**WEST SUSSEX COUNTY COUNCIL
COUNTY HIGHWAYS CONSULTATION RESPONSE**

SUBJECT: BE/17/18 - Proposed 2 bed bungalow.

37, Norbren Avenue, Bersted, PO21 5HE

Proposed Ground Floor Plan

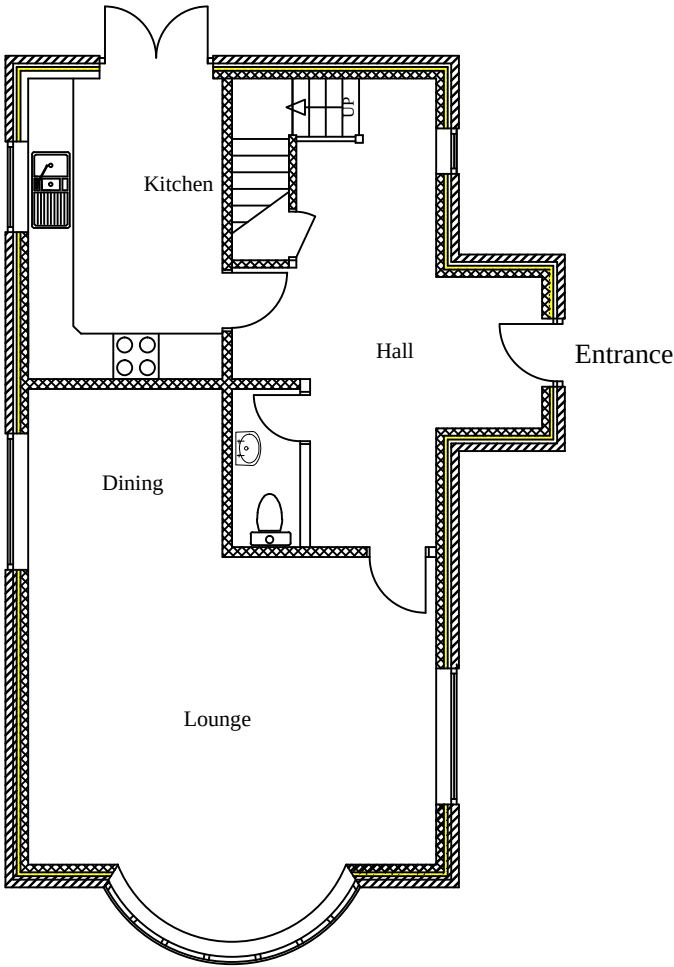
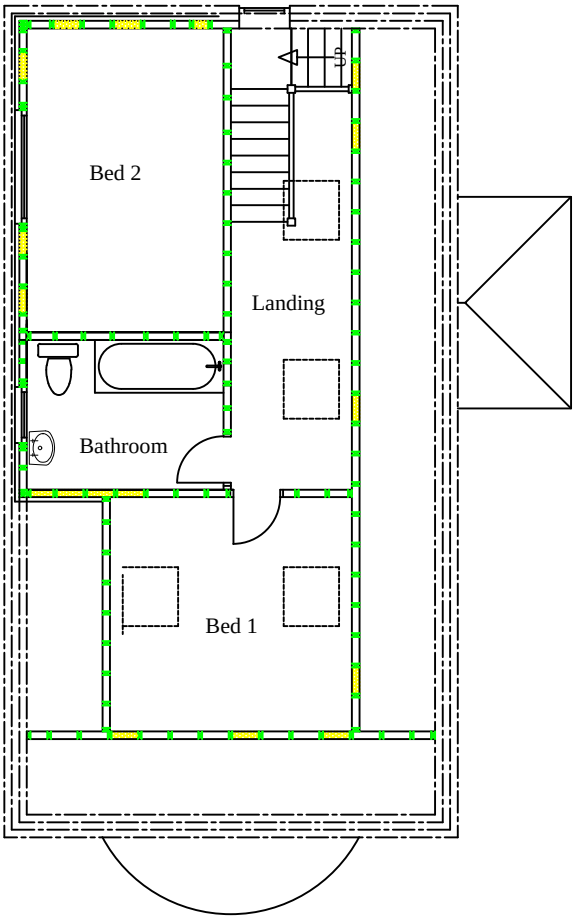
The proposed plans indicate that a hardbound driveway will be provided to serve the property. The existing dwelling, 37 Norbren Avenue, has an existing Vehicle Crossover (VCO) with dropped kerb access which is approximately 3m in width. A VCO will be required to serve the new dwelling, however this has not been demonstrated by the applicant. The new VCO would require a licence and to be constructed to a specification agreed with the Local Highways Engineer. Local mapping shows that there is an existing drain to the immediate west of the existing VCO, and plans for a new VCO should take this drain into consideration.

The LHA would advise that the boundary treatment to the West of the access is maintained to a maximum height of 0.6m to improve visibility of pedestrians on the adjacent footway. The LHA acknowledges that a pedestrian splay to the East of the access could not be maintained in perpetuity nevertheless Manual for Streets 2 (MfS2) paragraph 10.6.1 states that *vehicle exits at the back edge of the footway mean that emerging drivers will have to take account of people on the footway. The absence of wide visibility splays at minor accesses will encourage drivers to emerge more cautiously - similarly to how vehicles pull out when visibility along the carriageway is restricted.*

The application form refers to the provision of a single car parking space however from a measure of the plans there appears to be enough depth in the hardbound area to enable a second parking space if cars were parked in tandem. This meets the minimum requirements of 2.4 x 4.8m as set out in Manual for Streets (MfS). There is no turn on site, due to space limitations; however, this appears to be an existing practice for neighbouring properties.

No development shall commence until the vehicular access and crossover serving the development has been constructed in accordance with plans and details to be submitted to and approved in writing by the Local Planning Authority.

No part of the development shall be first occupied until the car parking has been constructed in accordance with the approved site plan. These spaces shall thereafter be retained at all times for their designated purpose.
